Letter No. BI/260/2003

Sub: -CMDA - Area Plans Unit - Planning Permission -  
Proposed construction of Ground Floor + 3Floors,  
Ground Floor, First Floor & Second Floor  
Commercial Building and Third Floor Residential  
Building with 1 dwelling units at Door No.32,  
North Usman Road, T. Nagar, Chennai-17 in T.S.No.  
4753/16, Block No.108-A, T. Nagar - Development  
Charge advice sent - Regarding.

SECTION ON X-Y

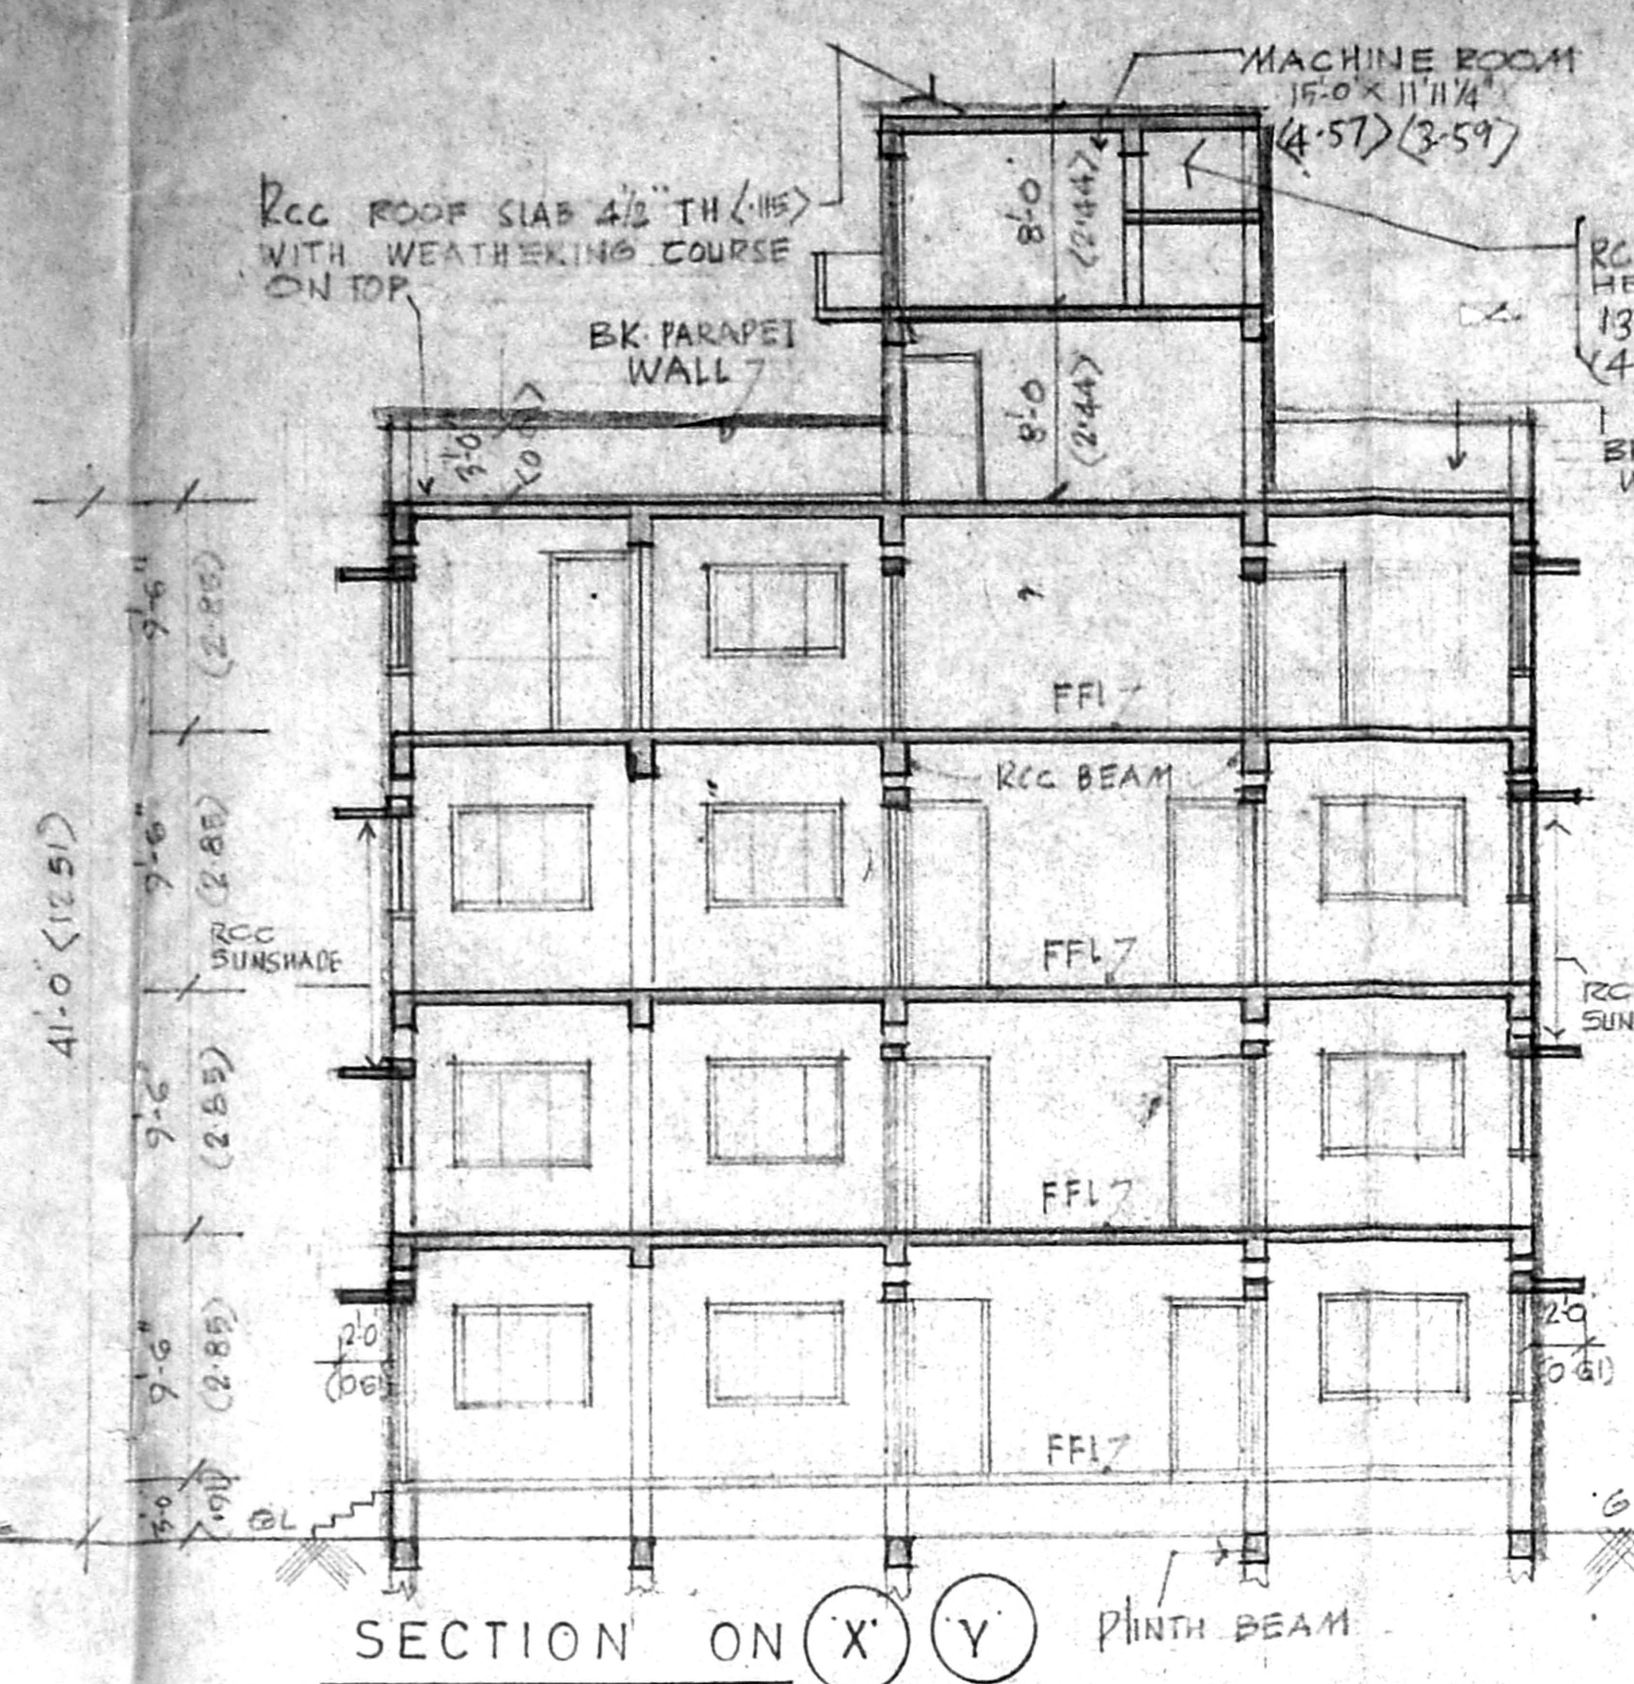
1. setbacks to be shown correctly in Northern side.
2. section to be drawn correctly.
3. Dwarf wall of 7.50cm height to be shown near the gate.
4. Two more carparking lots to be shown in the site plan.
5. site plan is to be drawn showing dimensions both as per patta and as at site and distinguishing the difference by hatched indication and indicating the setback from least dimension line.
6. portions encroached by adjoining land owner specified in the site plan in the eastern boundary to be deleted.
